# COLORADO

May 11, 2022

Re: Sand Creek Channel Designs CDs

11/20/23

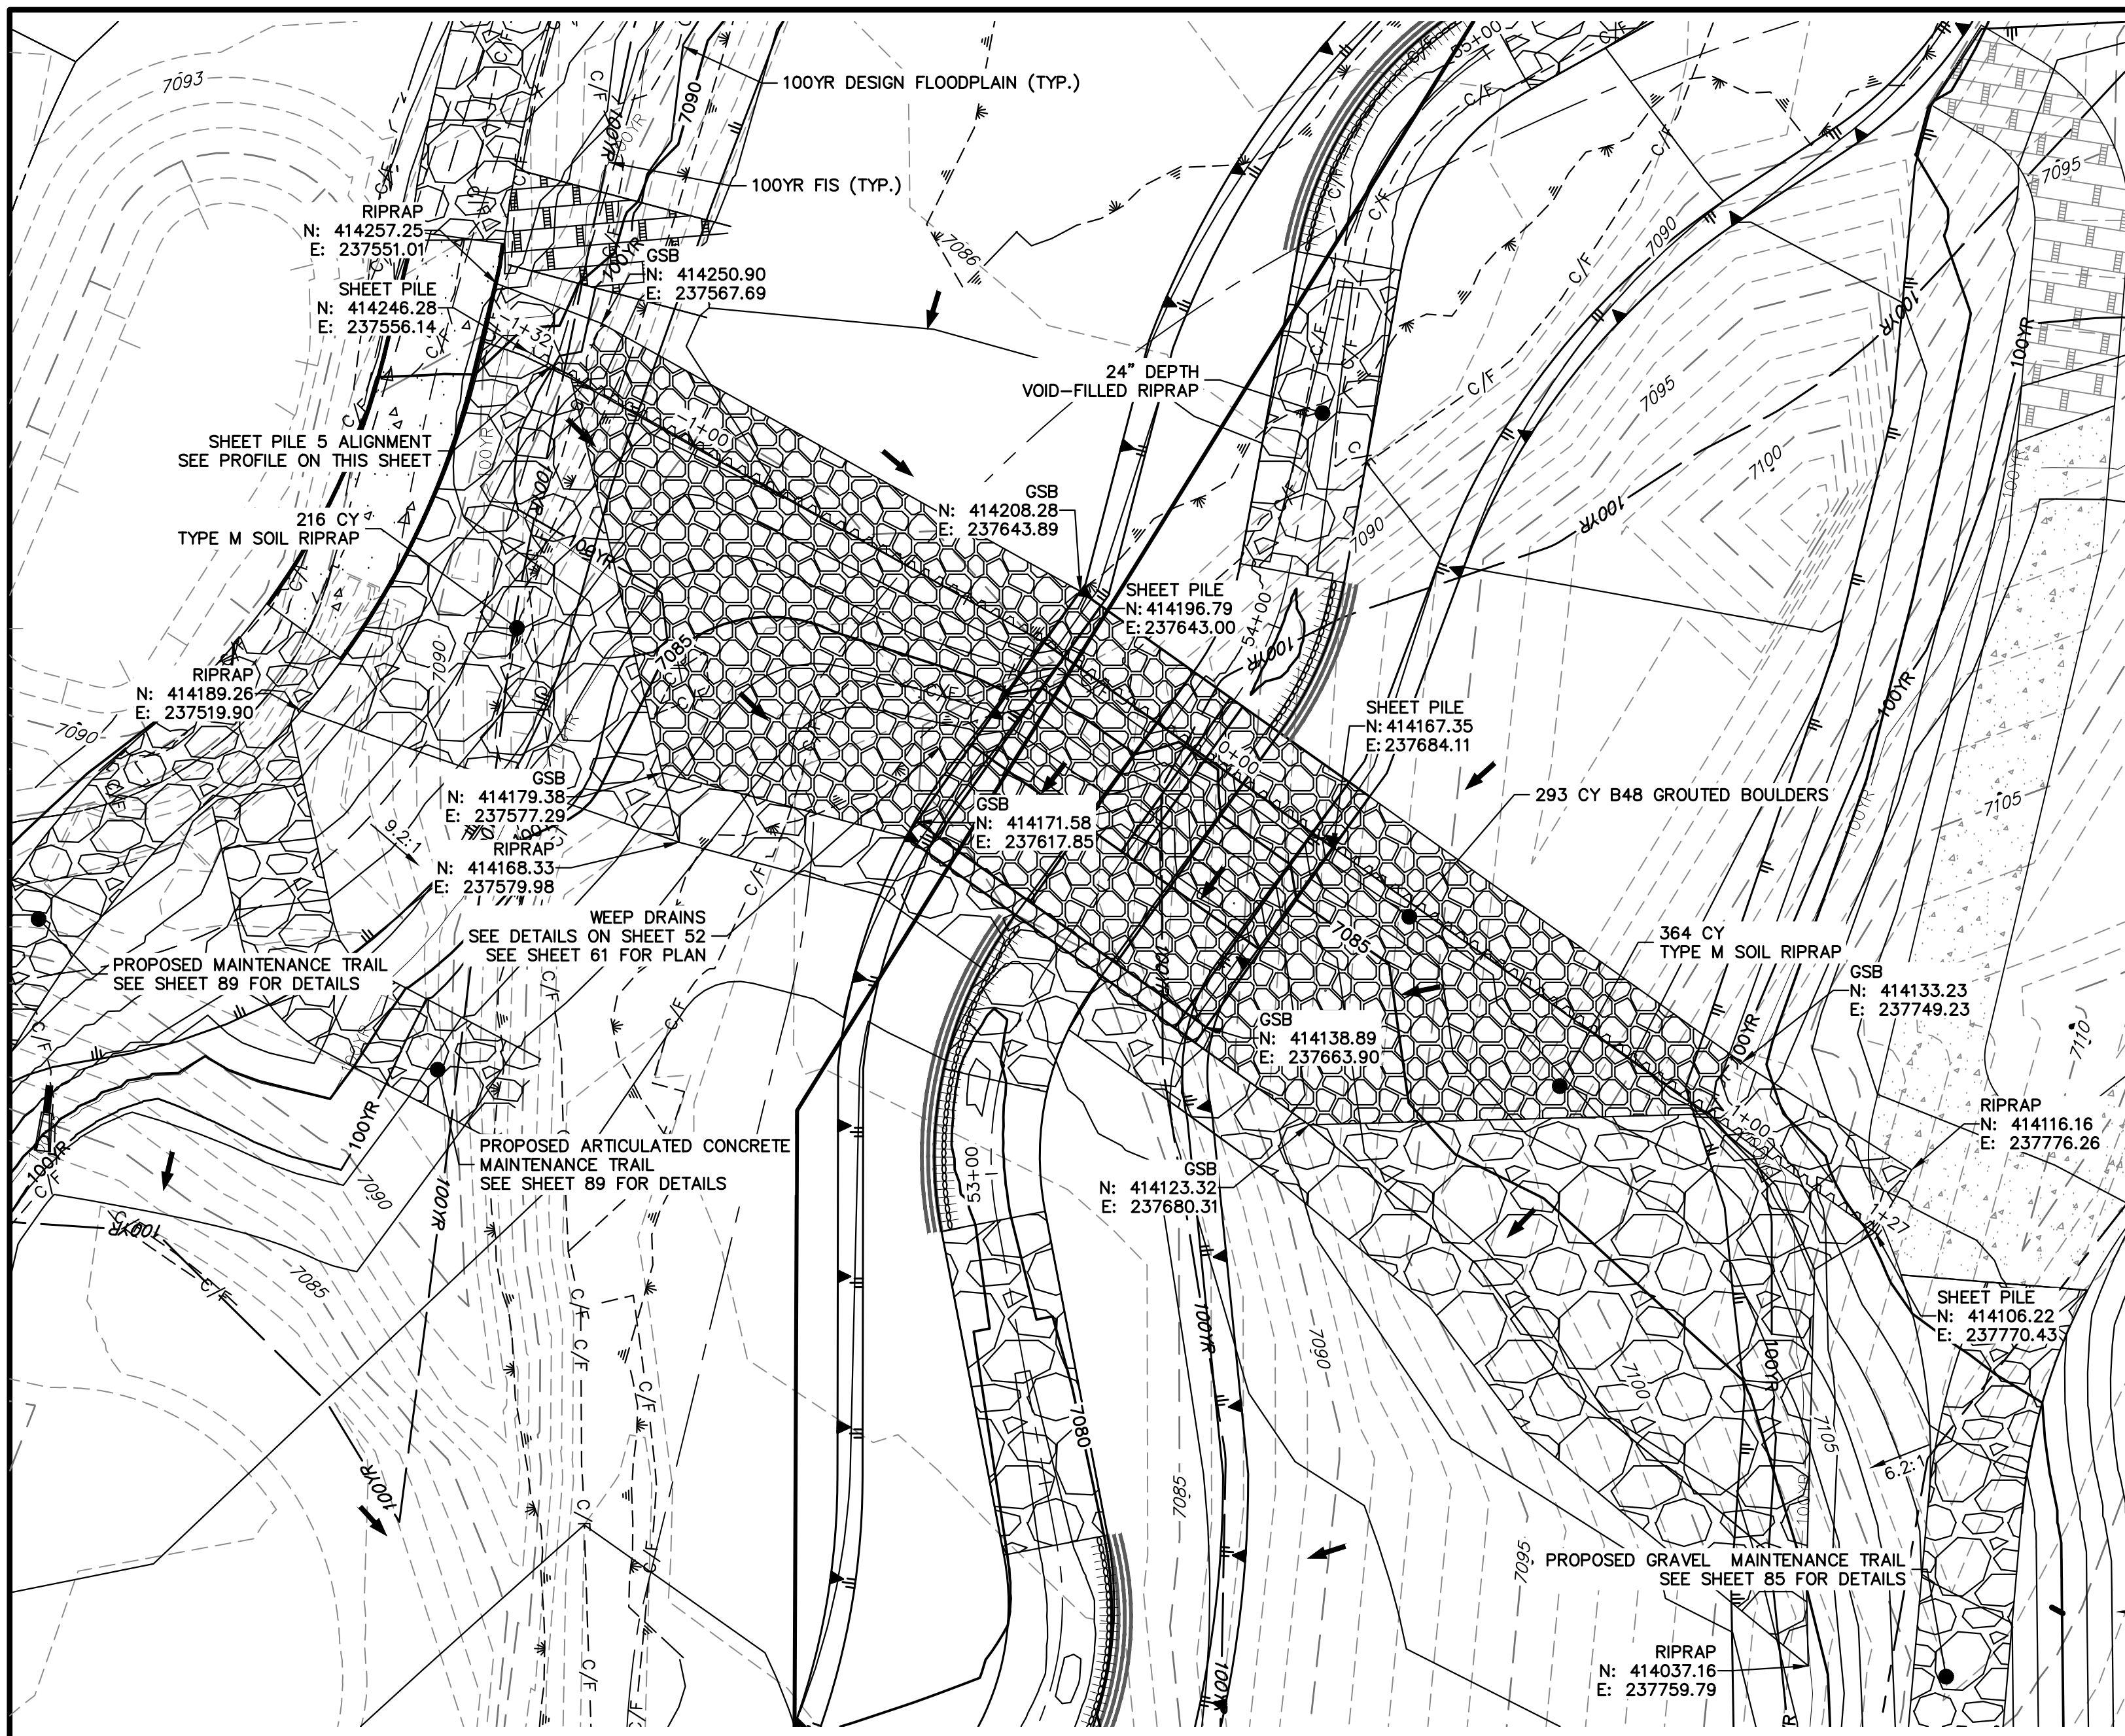
CPW noted in the designs of the channel that most of the rip-rap throughout the project are not grouted. However, there were sections of the channel design that were grouted drop structures. CPW recommends using non-grouted rip-rap throughout all portions of the plan.

Vegetation and tree roots are more stable in non-grouted rip-rap and it can help provide habitat for small mammals. This not only benefits wildlife, but makes the construction more aesthetically pleasing.
